MECKLENBURG COUNTY
Park and Recreation Department

MEMORANDUM

DATE: January 13, 2022

RE: Rezoning Petition #2021-215
PID# 03144101

SCHEMATIC  
SITE PLAN

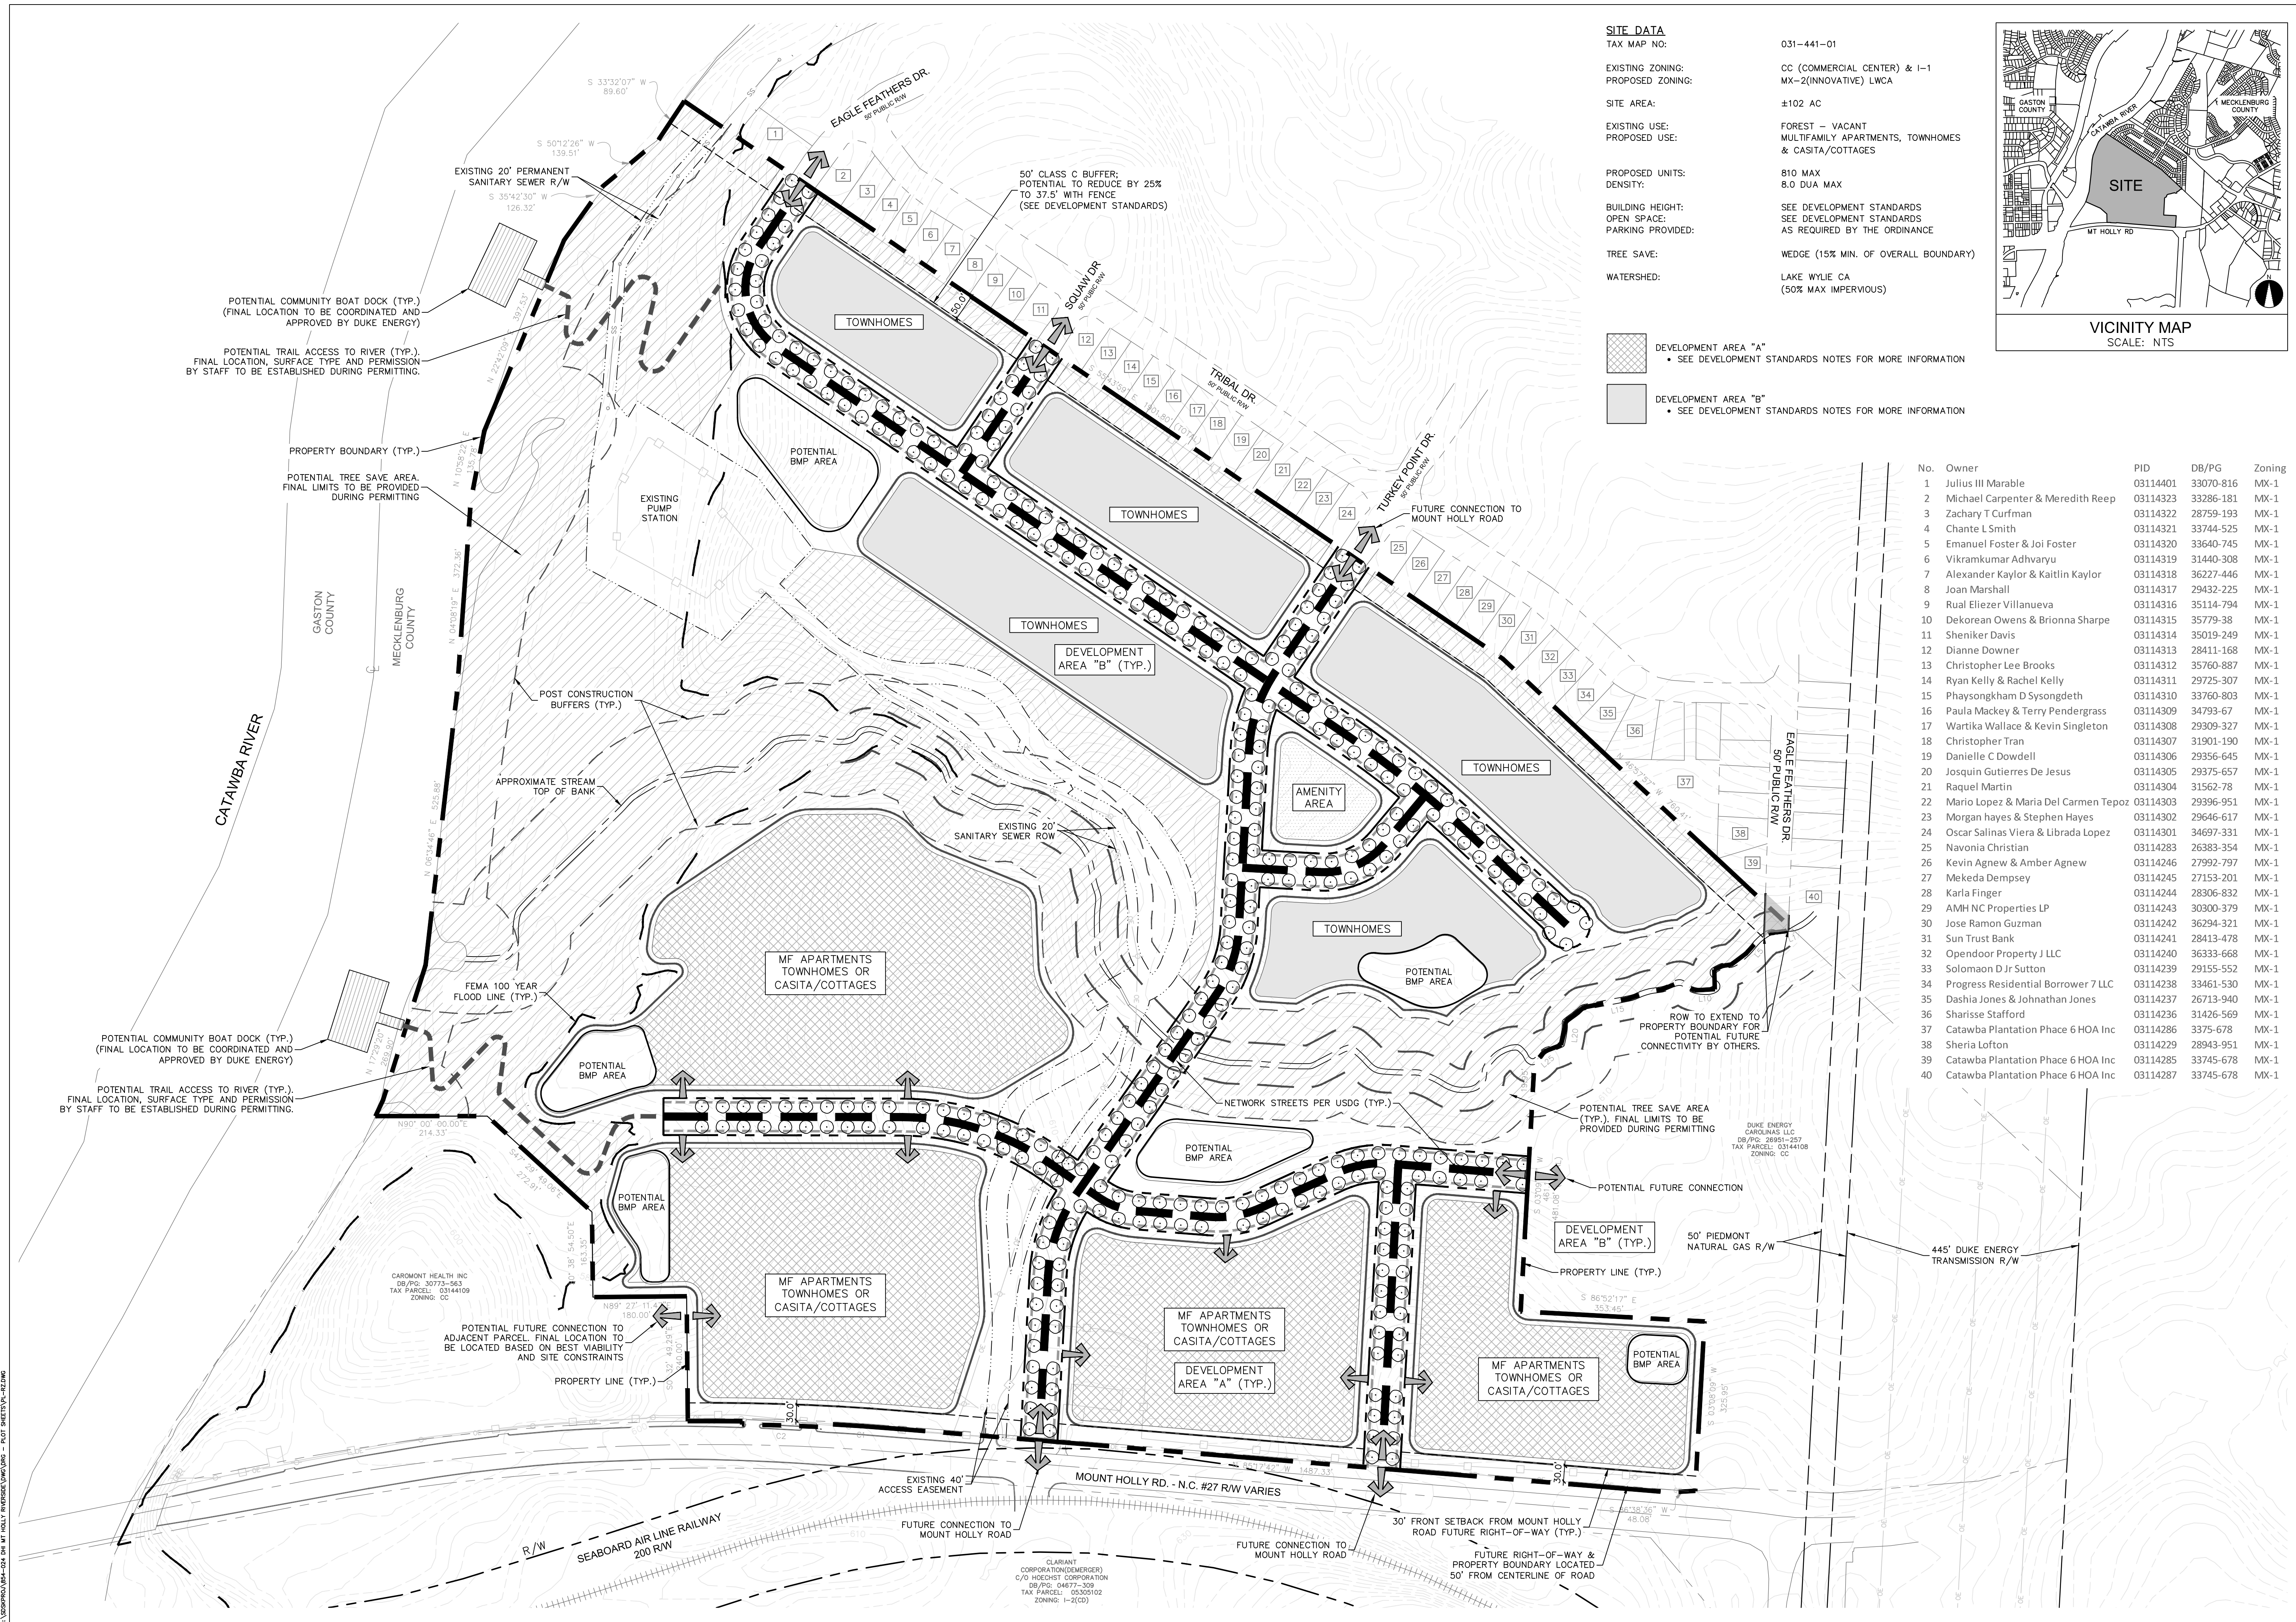
MCPR requests a minimum of 5 acres to be dedicated and conveyed to Mecklenburg County for a future neighborhood park. This requested park land shall be adjacent to a public right-of-way for access and is conducive for the development of the typical amenities found in a neighborhood park and cannot include tree save parcels.
